**DELEGATED DECISION FOR DISCHARGE OF CONDITION -
NOTIFICATION OF AGRICULTURAL DEVELOPMENT**

Reference no. 2025/N /90652/W

**Site Address Foster Place Farm, Foster Place
Lane, Hepworth, Holmfirth, HD9
7TN**

**Description Prior notification for erection of
agricultural building**

Drawing
Elevations

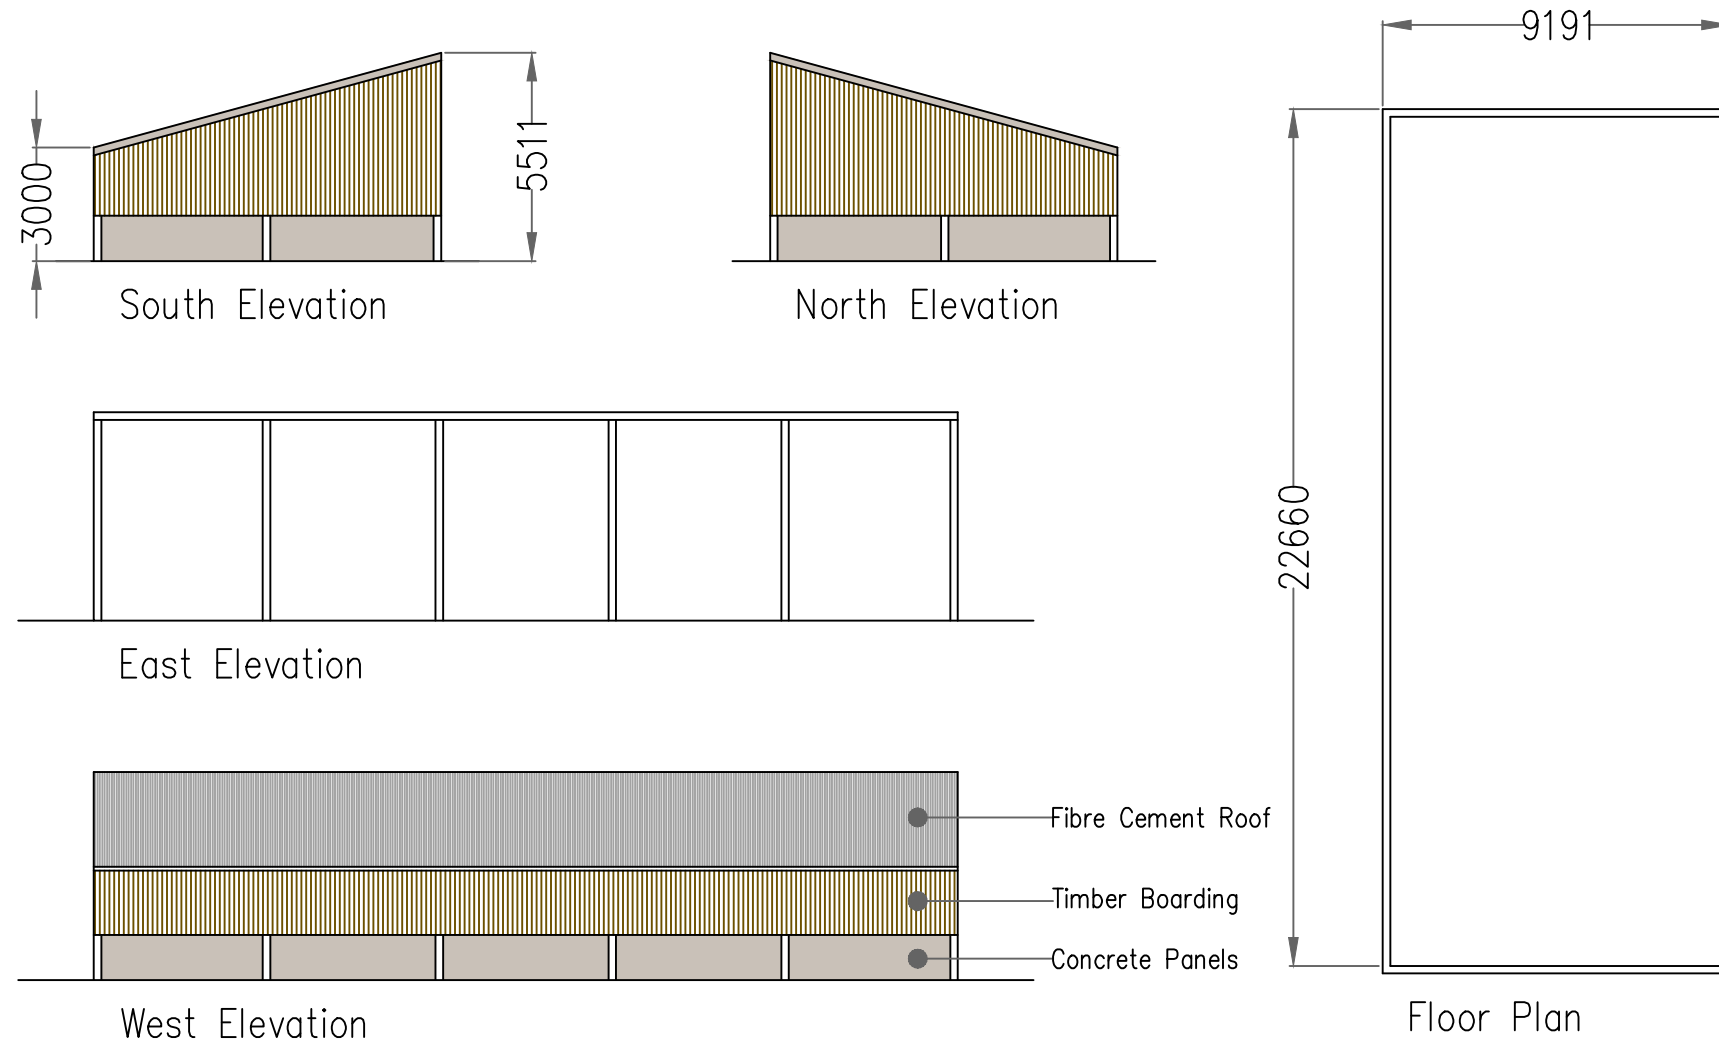
The walls are proposed to be constructed from concrete panels and timber boarding. The roof is indicated to be a fibre cement roof material.

| <p>(g) the height of any part of any building, structure or works not within 3 kilometres of the perimeter of an aerodrome would exceed 12 metres;</p> | <p>Pass: The building would be 5.1 metres in height.</p> |

The building would be open sided, with the open sided element facing eastwards. To the south, north and western elevations the building would be solid sides constructed from concrete base boards / timber walls and with a profile concrete sheeting roof.

The design of the building is typical of that which would expect to be seen within an agricultural setting and the scale of the building, whilst not unsubstantial, would be viewed in the context of the wider agricultural land and operations. The proposal would see a blank elevation 26m from the highway to the west, although it is considered that to reorientate the building in the site would introduce the same relationship in respect of the highway to the south.
